From: Norman, Phil
Sent: 12 August 2014 15:30
To: _planningadvice
Subject: FW: H16-0348-14
[Please scan to H16-0348-14 as 6SUP.](#)

In respect of H16-0348-14 (land between Springfields and Fulney Hall) I have the following comments/queries.

1 Site Block PLan
1 : 100

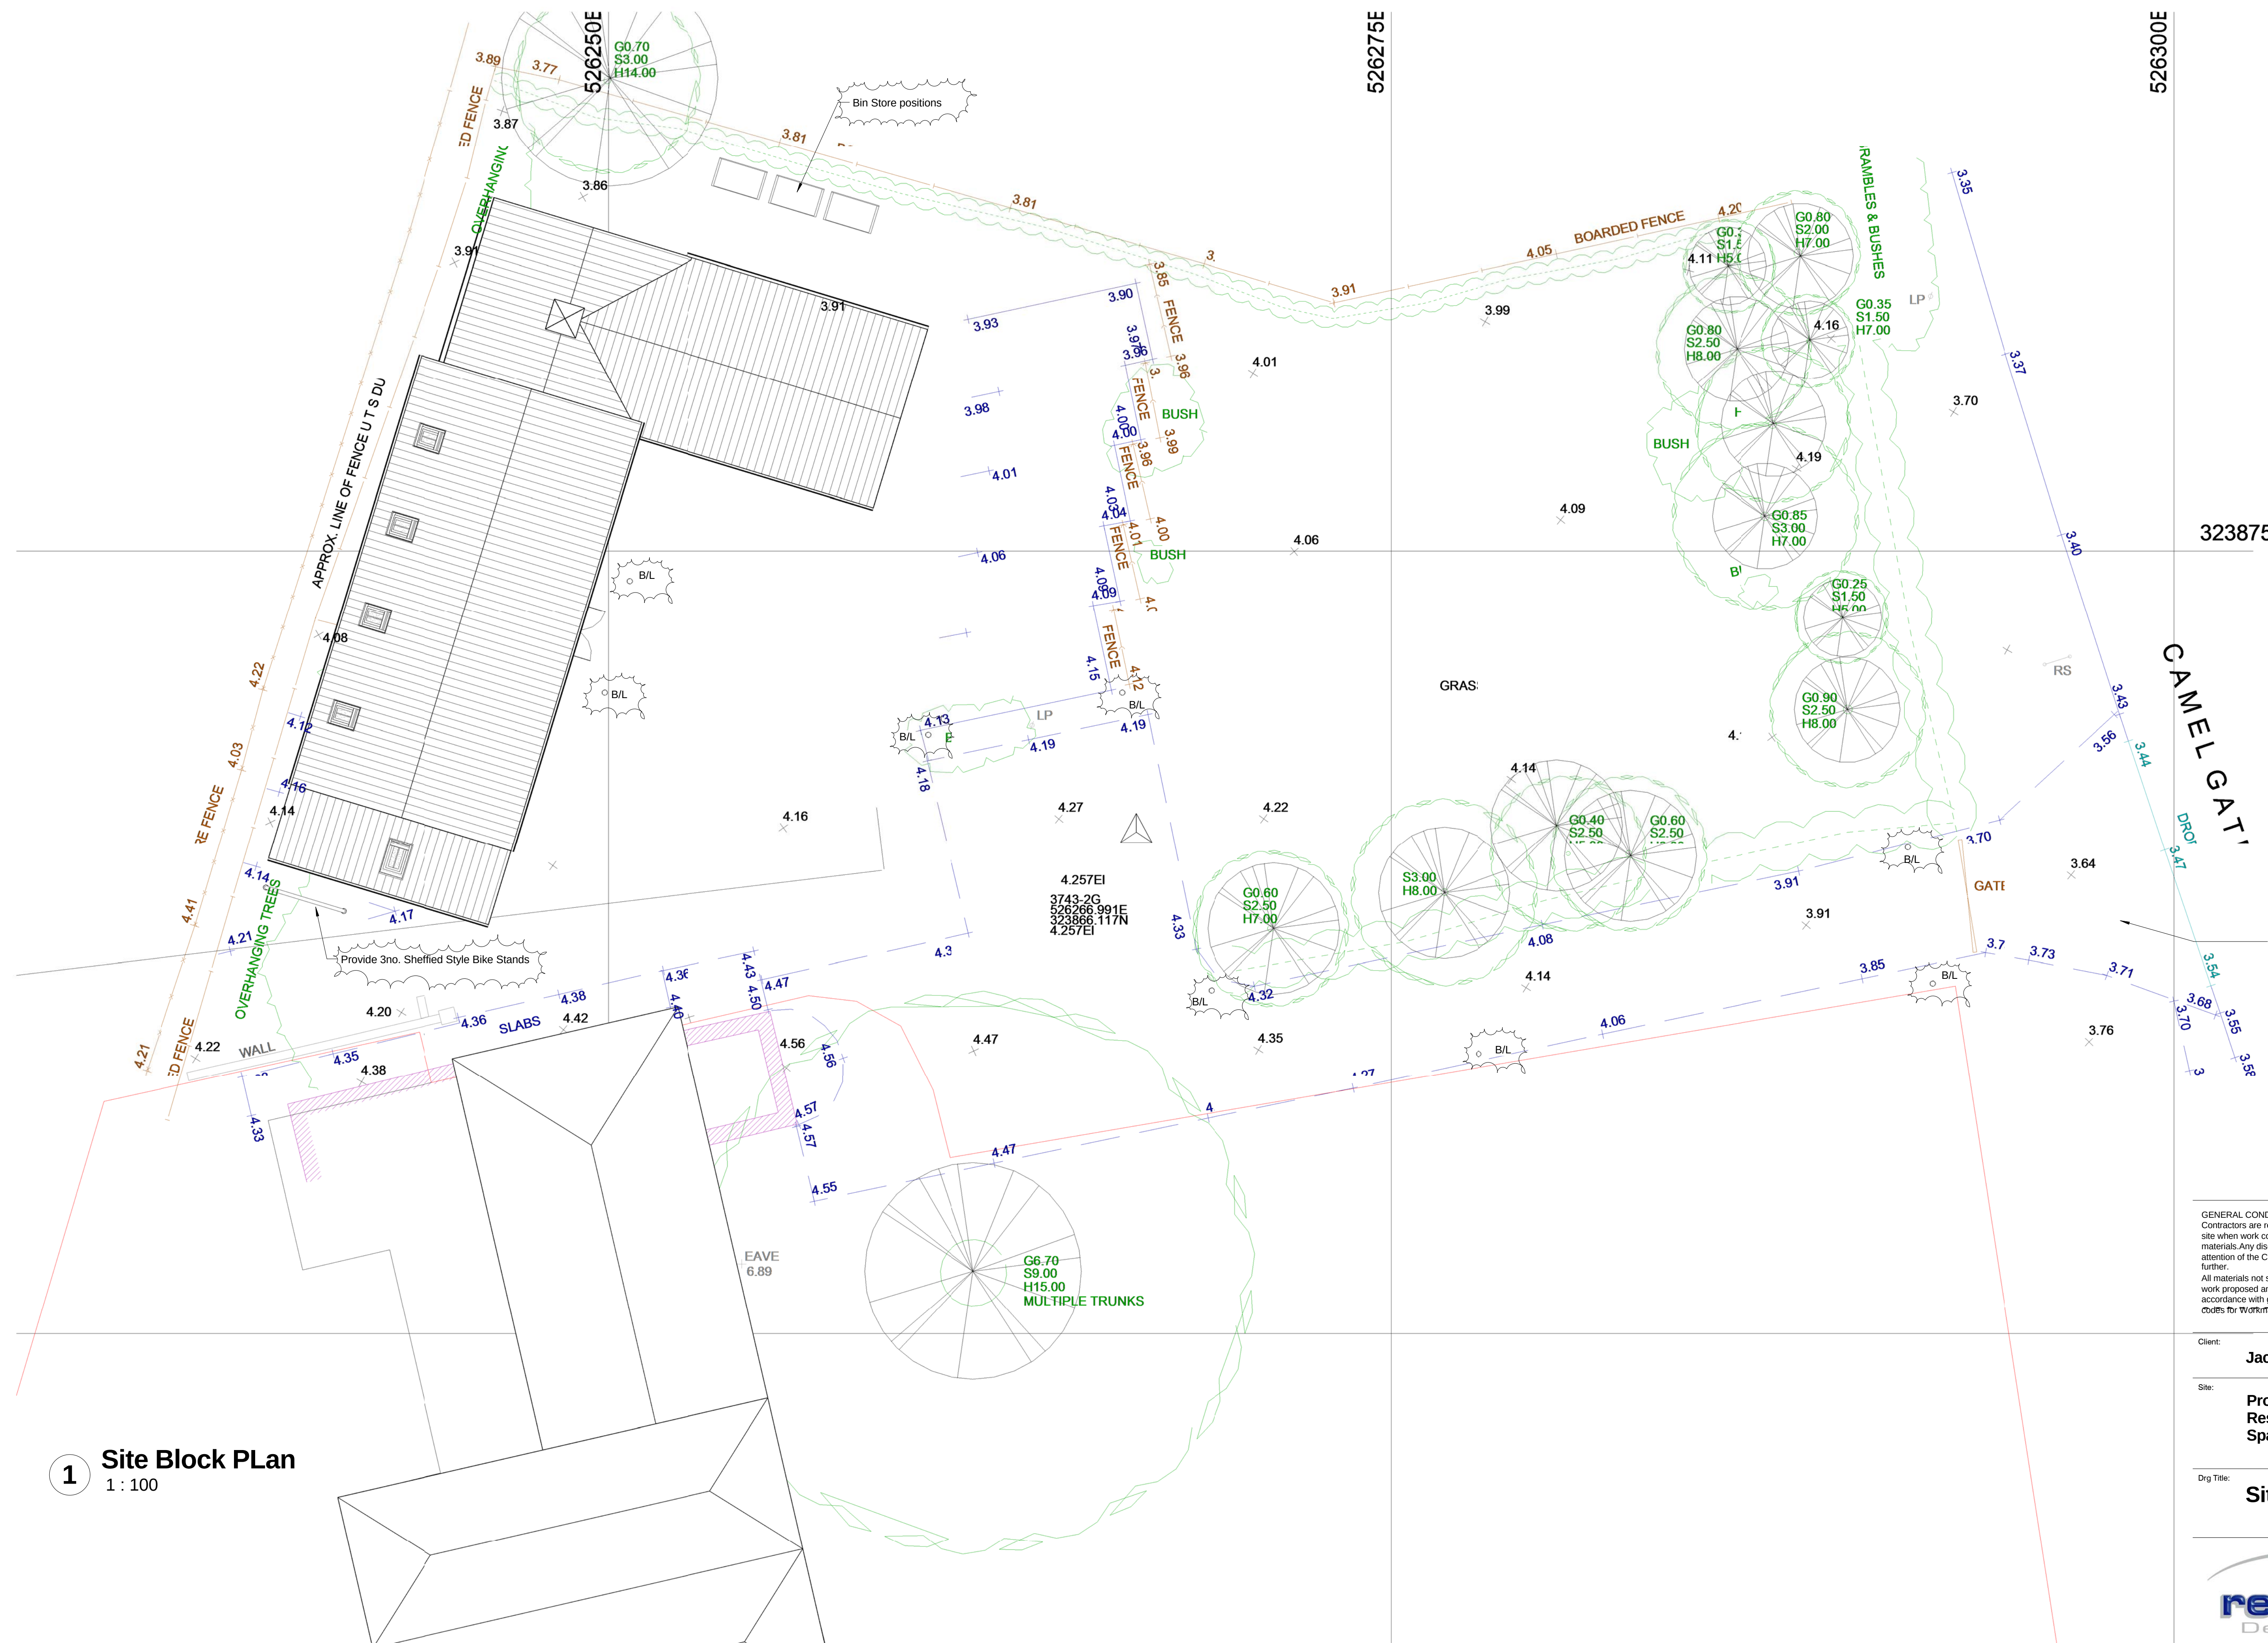
In respect of condition 6, please could you confirm that these are to be commercial waste bins, to be collected by a commercial waste contractor. How often are these to be collected?

I can confirm the commercial waste bins will be collected once / twice a week by a private contractor which is standard practise for this type of business.

1 Screen Elevation
1 : 20

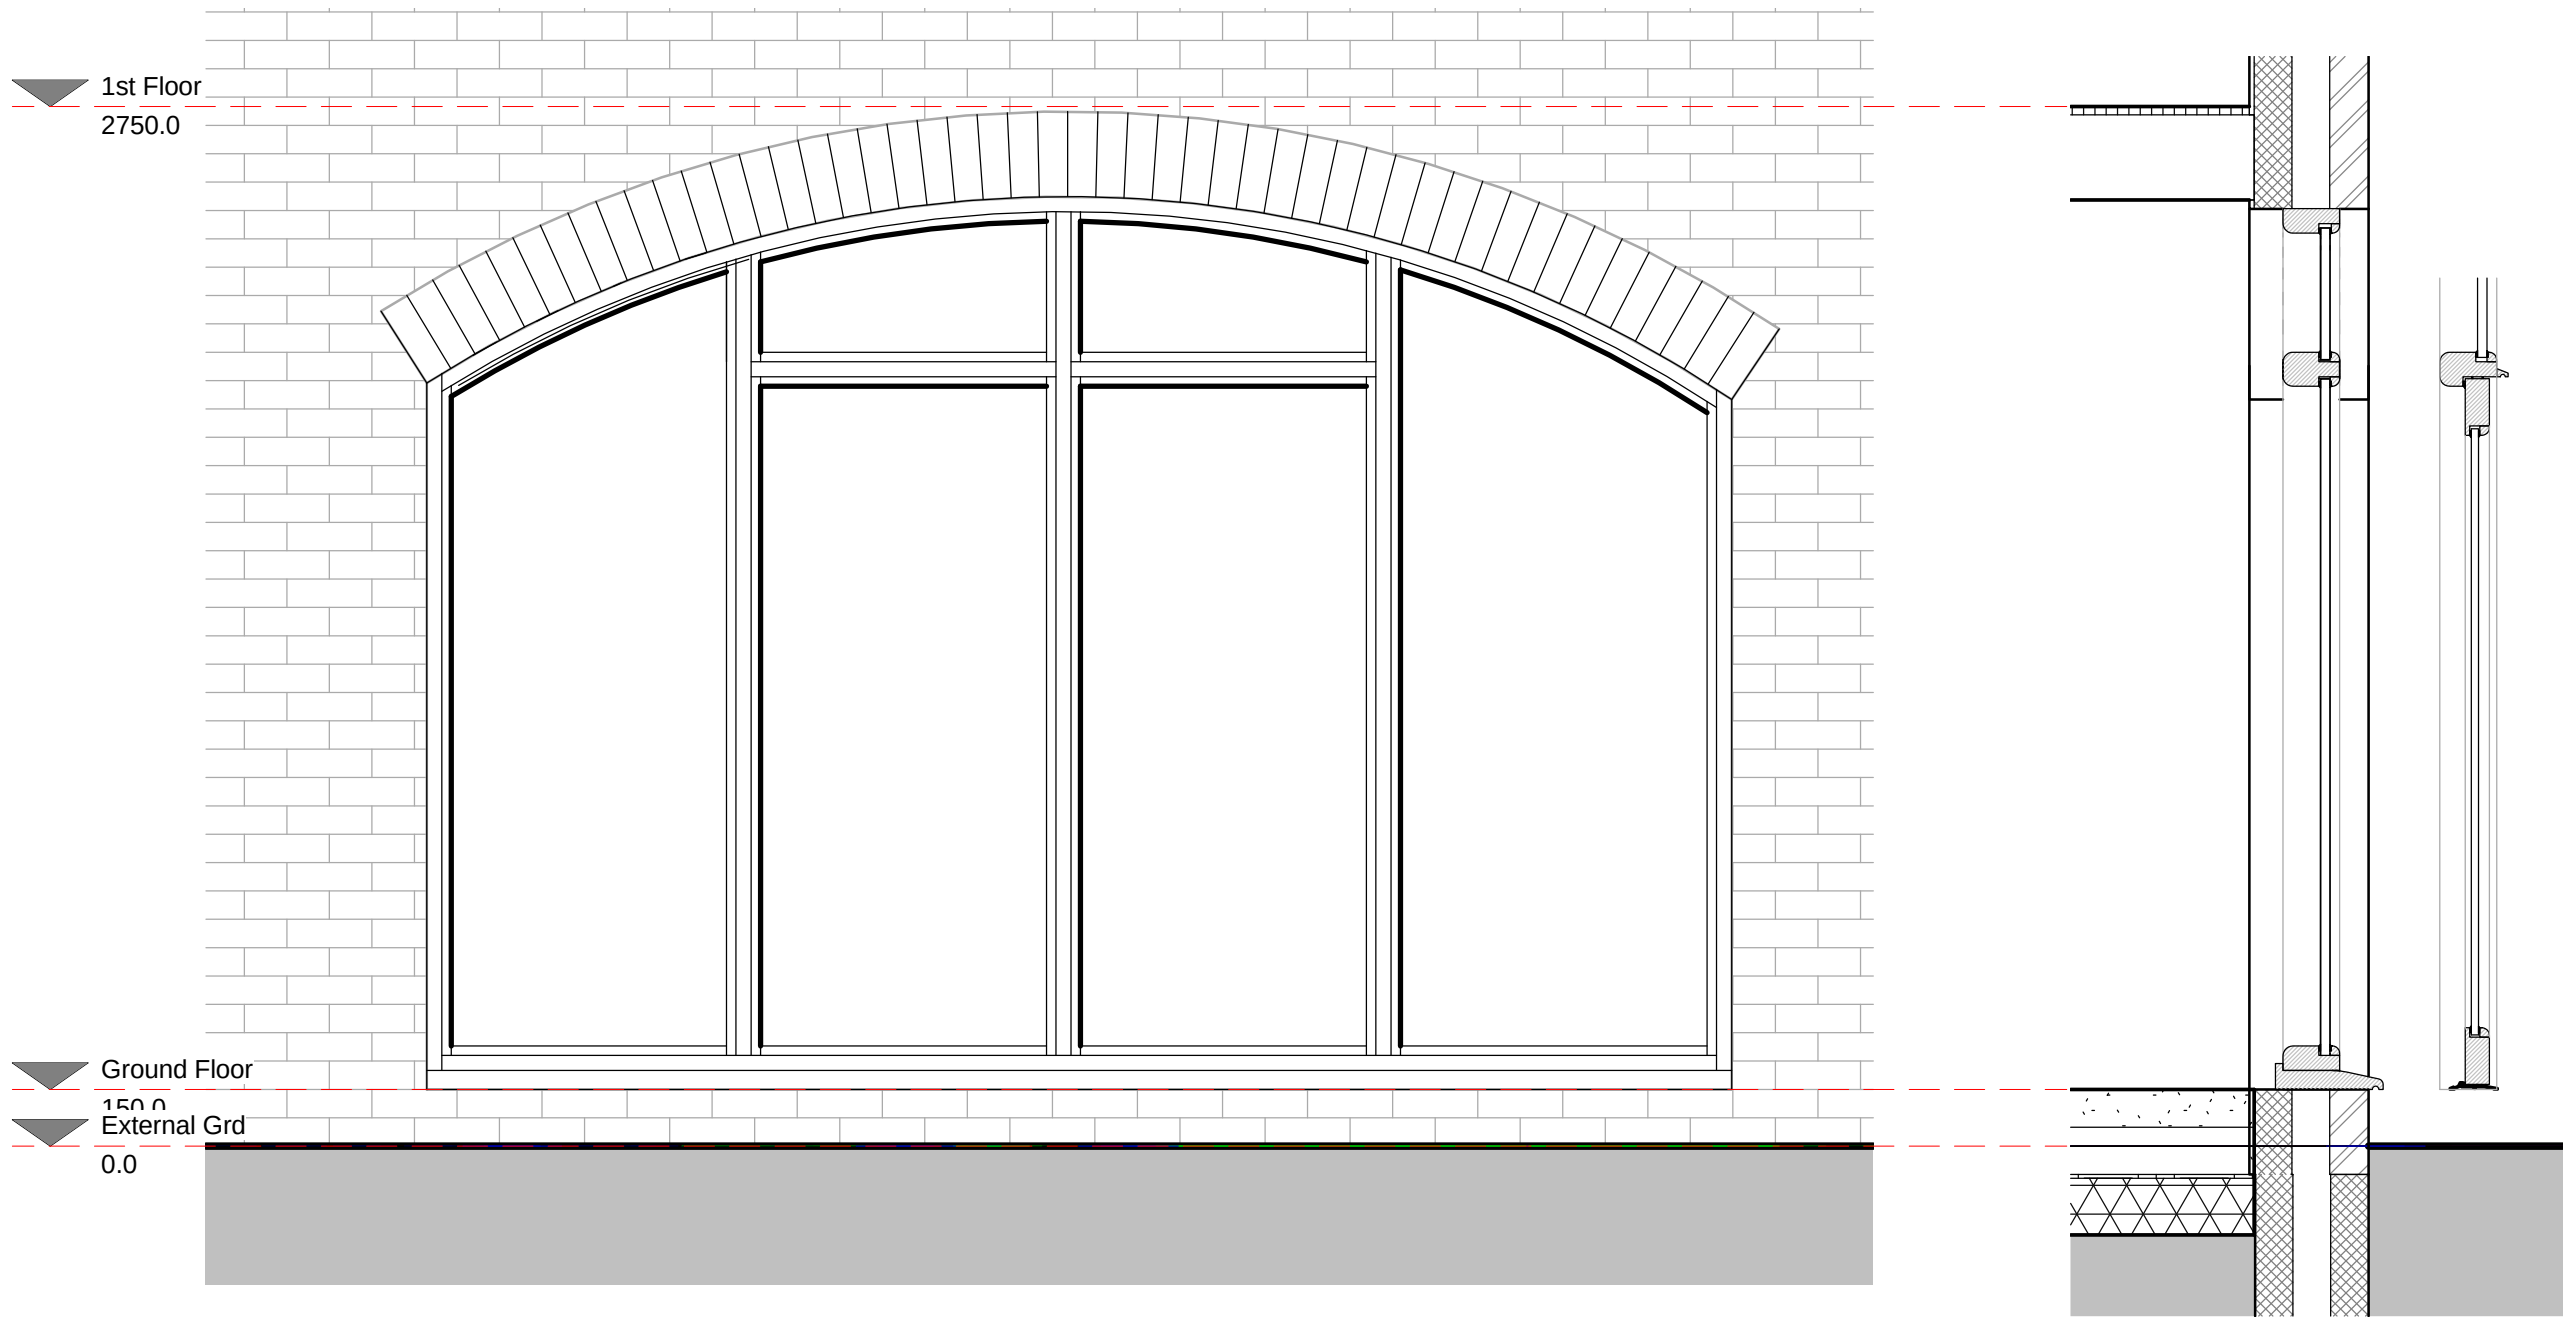
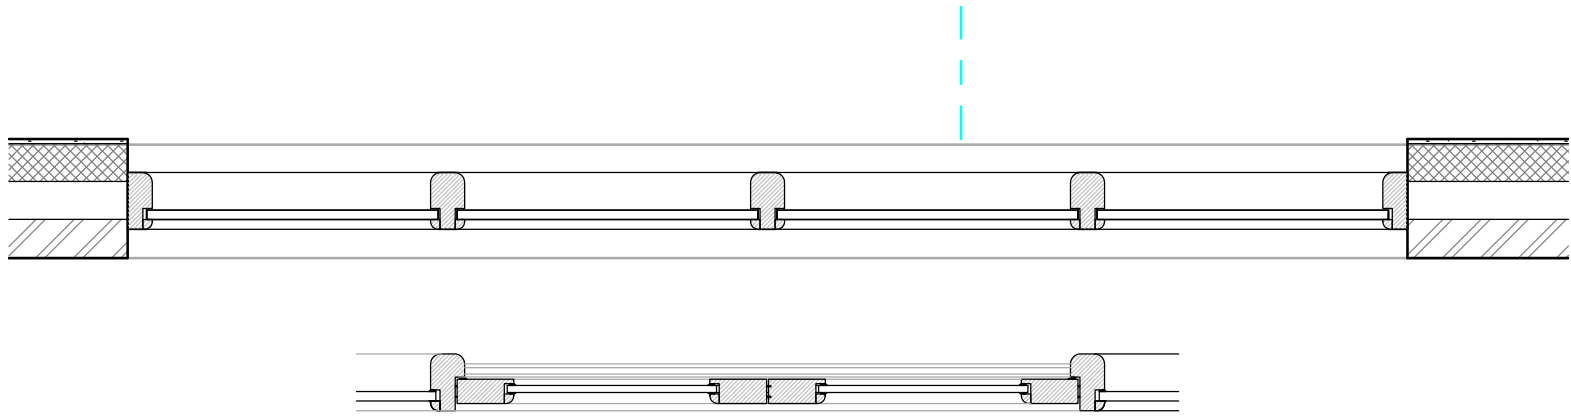
Condition 16 is not part of this current application, however, can you confirm how you intend to address this in due course?

The freestanding brickwork panel will be constructed on site and the condition discharged at a later date
